1 No. dwelling with detached garage (part resubmission following R/91/17/PL & R/204/18/PL).

Springfield House Springfield Close Rustington

Thank you for your internet representation made on 4th November 2019 which has been recorded as '**an objection**' with the comments as follows:

Job Title	Springfield House		
Client	Castle Property Developments		
Drawing Name	Garage - Plan & Elevations		
Drawing Status	Planning		
Drawn by	DF	Date	Sept 19
Checked by		Date	
Drawing Scale	1:50 & 1:100 at A1		
Drawing No	Status	Revision	
181303/	09

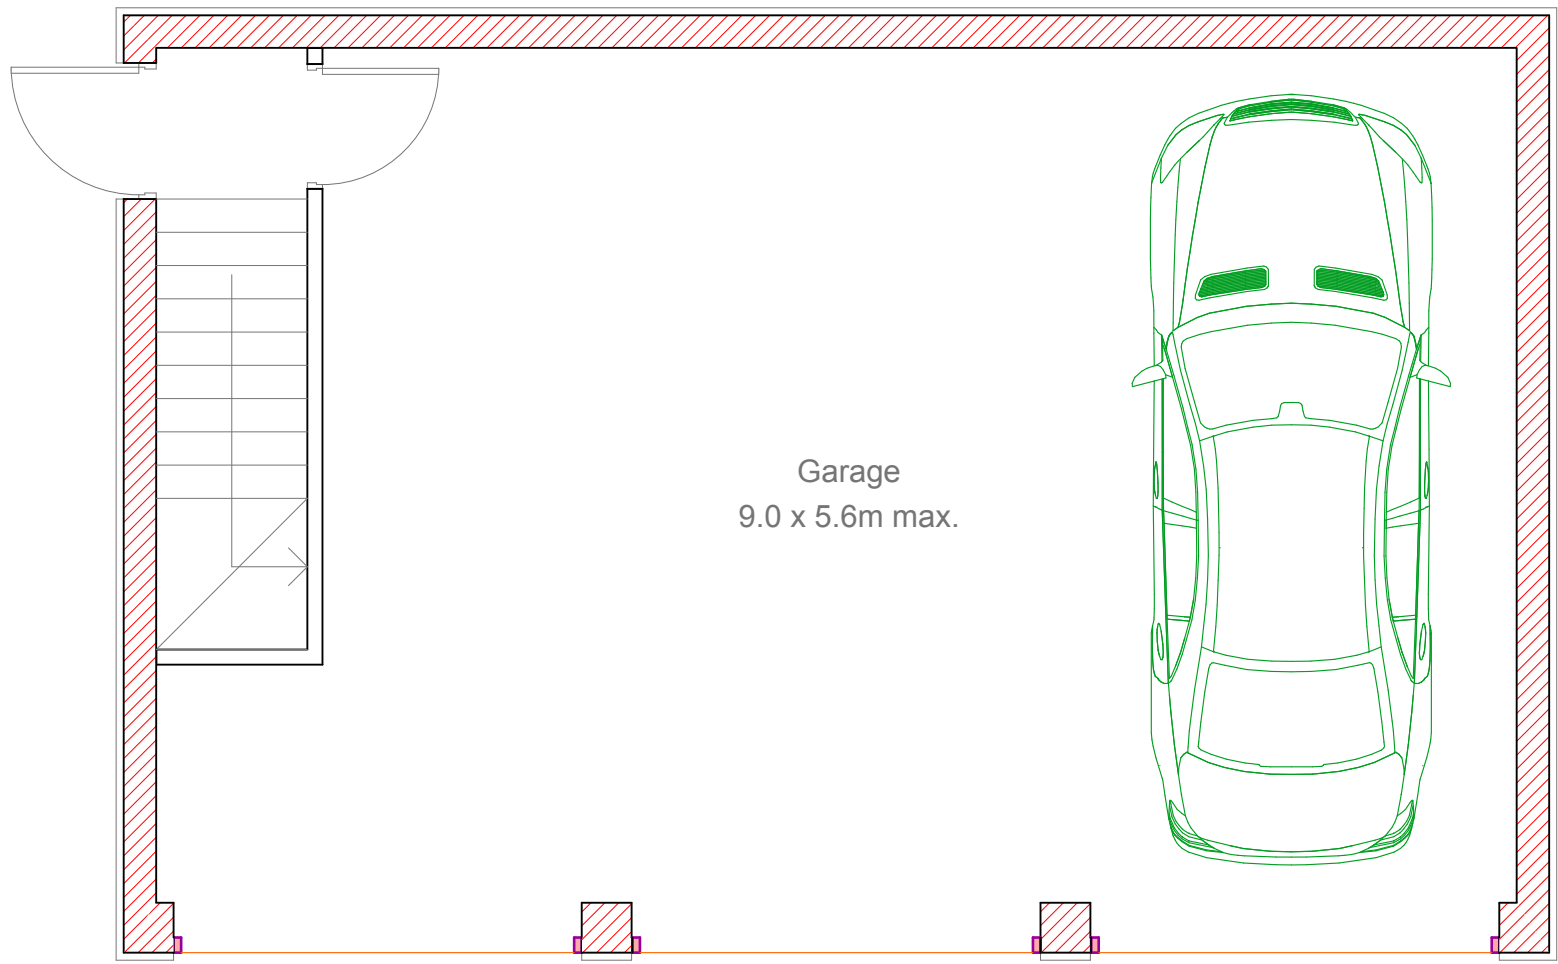
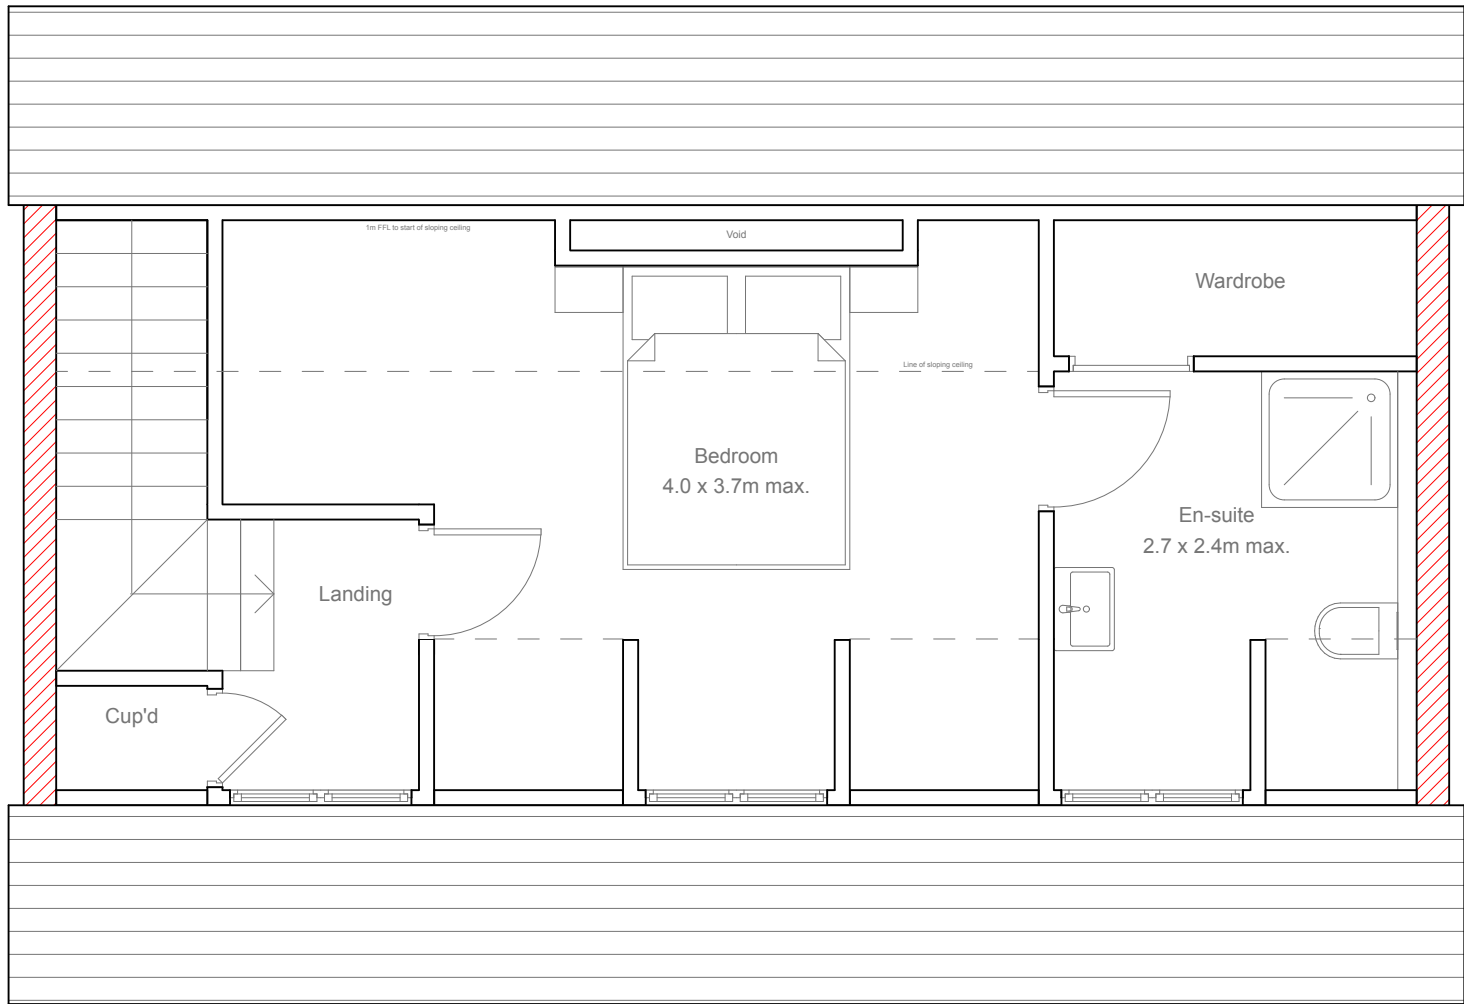
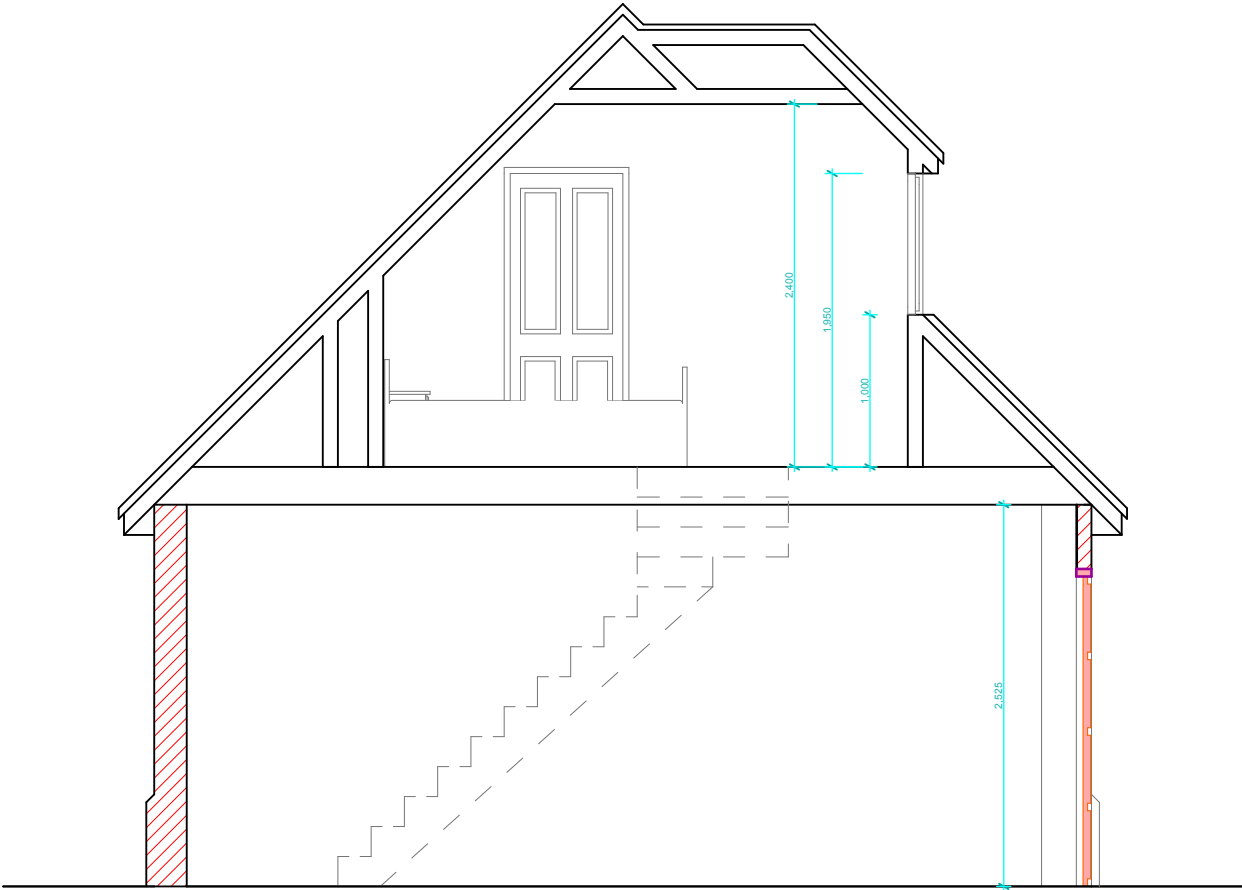
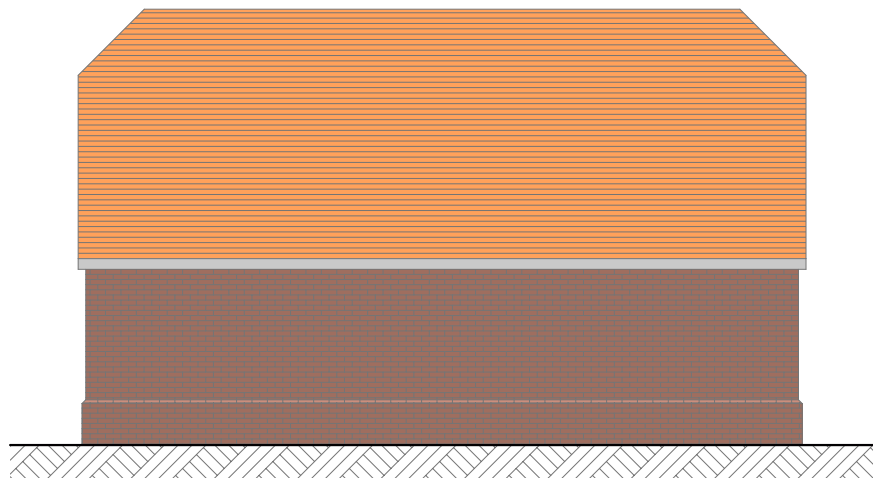
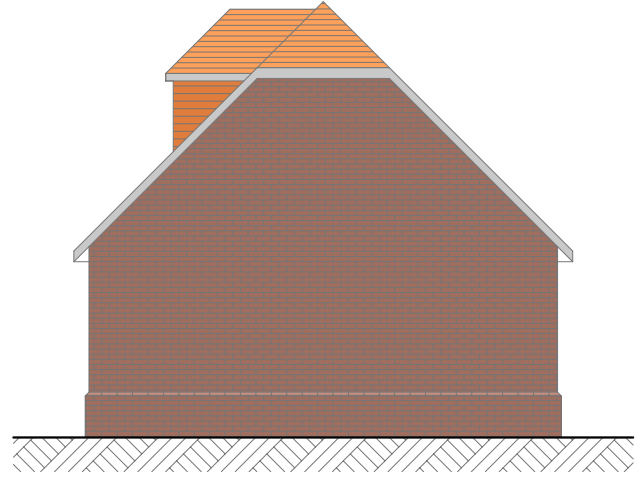
Further to the site notice seen for Planning Application R/230/19/P, we write to object to the proposed relocation and significant enlargement of the garage onto the eastern boundary and to the accommodation on the first floor of the garage. We own the neighbouring property to the east of the Application site and will be directly affected by the proposal.

The existing Planning Permission locates the approved double garage well away from our western boundary, meaning that an appropriate distance is maintained between the built forms across the two dwellings and most importantly provides an area for landscaping to provide adequate visual separation between the houses. The proposed location of the garage block in this Application renders this impossible, with only a notional 1m gap to the fence boundary. The building will be highly visible from our garden given its insensitive design; a large gable will be present only 1m from the boundary as a direct result of the intent to provide accommodation at first floor; this is completely contrary to the existing consent which had a garage building with a low pitched roof to be subordinate to the main house.

The proposed building has now increased dramatically to a triple garage and first floor accommodation from the approved much smaller double garage. Positioning the new garage block as proposed will create an uncomfortable relationship with our garden and provide anyone using the bedroom above the garages the ability to look directly in a south easterly direction into our garden from any one of the 3 dormer windows proposed. Applying for additional accommodation is unnecessary in itself given the size of the approved house, and the plans suggest that this could become a self-contained annexe separate from the house. This is completely at odds with the current Planning Permission.

We believe that the proposed building has both an overbearing and overlooking impact on our property, decreasing the ability to quietly enjoy our garden. The large gable will loom ominously over our eastern boundary and be a very hard edge to the current unencumbered views of the boundary trees. We believe that the proposed garage has been 'shoehorned in' to try to (just about) avoid the trees on the northern boundary, namely Trees 16 and 17. The previous siting of the garage fully respected the RPAs of T16 and T17, but the proposed large block appears to encroach into the RPAs to a more significant degree than the Arboricultural Report would appear to suggest. No details of foundation design have been provided, however the likely strip foundations will have an effect on these trees.

To conclude, we object to the siting, scale, massing and design of the proposed garage block and additional annexe accommodation for reasons of inappropriateness, significant overlooking, overbearing impact on our garden, likely impact on Trees 16 and 17, inappropriate landscaping provision to the site boundary and most importantly the loss of privacy to our property caused by the proposed new accommodation. We would respectfully ask that the Planning Application is refused.
